Our Ref: EG/69/17/PL
Your Ref:

Town & Country Planning Act 1990 (as amended)
Town and Country Planning (Development Management Procedure) (England) Order 2015
Application for Planning Permission

Development 4 No. live/work units, Research and Development propagation building & growing area, garden room, fuel store & greenhouse to main dwelling & formation of new access. This application is a Departure from the Development Plan.

Location Swallowfield Eastergate Lane Eastergate

GARDEN SHEDS: Made to measure by:-
Elford's sheds (Chichester) LTD, Units
1 & 2 Ben Turner Industrial Estate,
Oving Road, Chichester, PO19

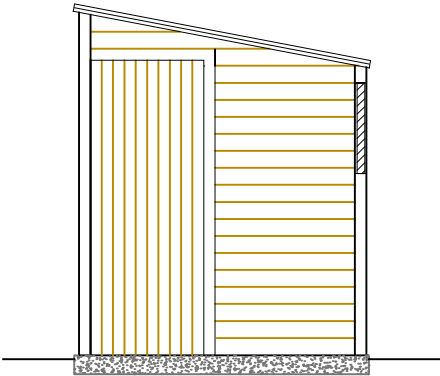
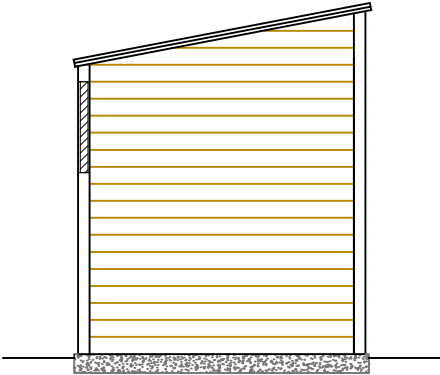
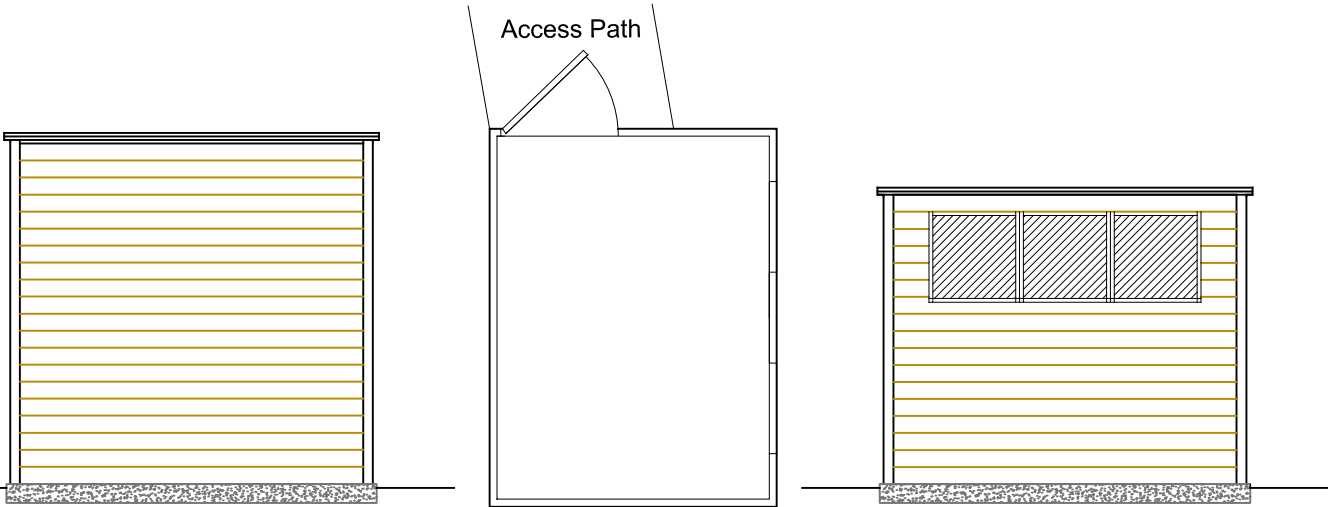
Please provide floor plans and elevations for the proposed cycle/shed.

Drg No 0790 - 04

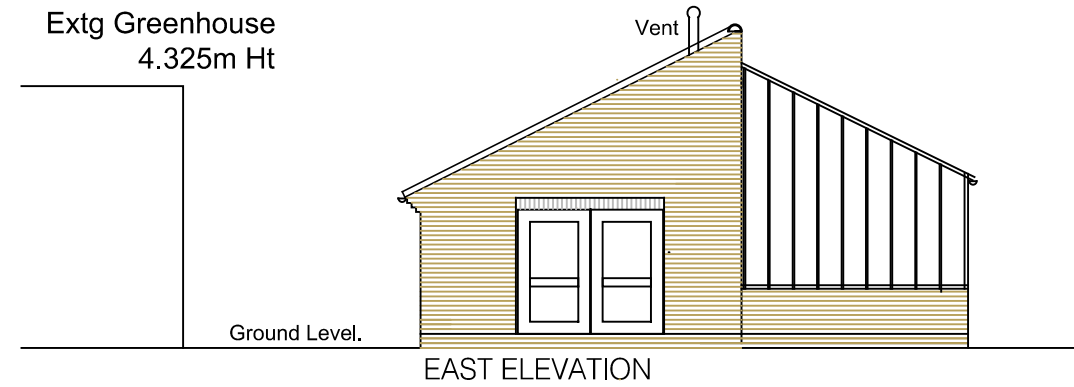
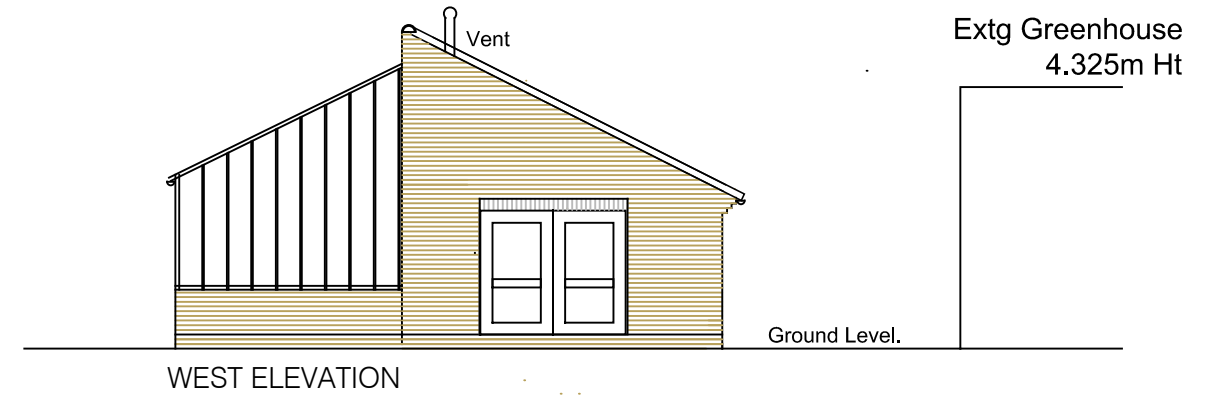
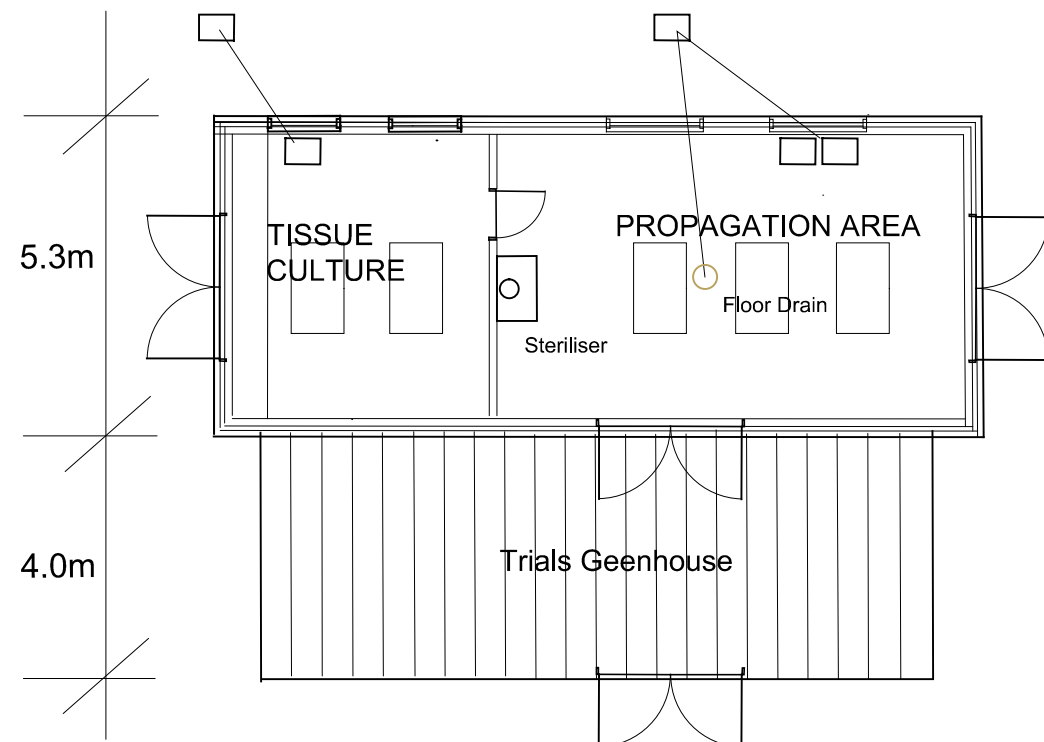
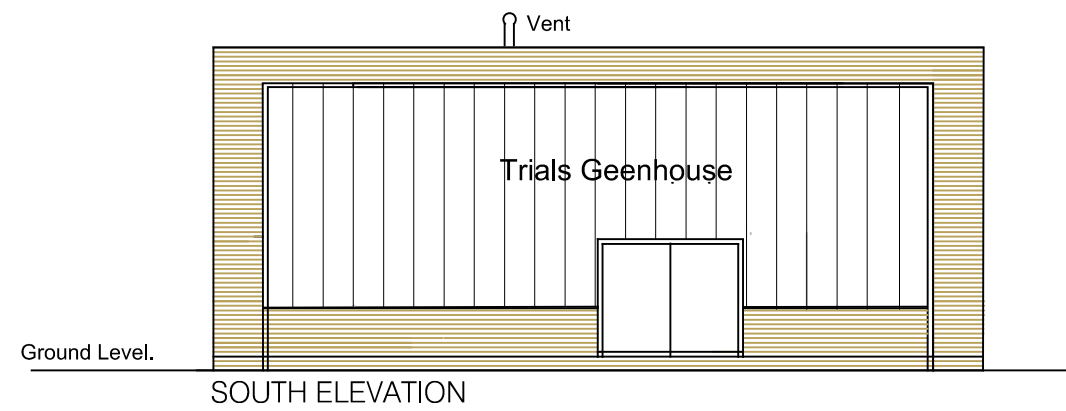
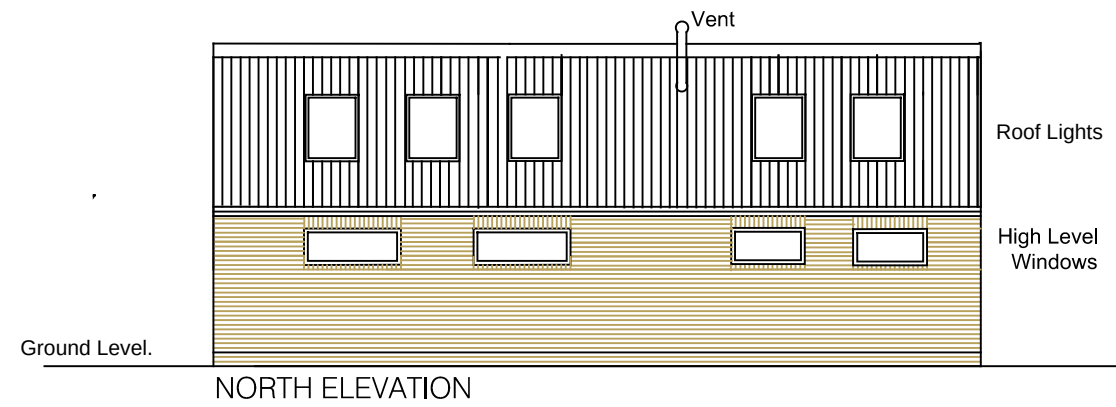
Please show all rooflights on the floor plans of the R & D Unit (drg 04).
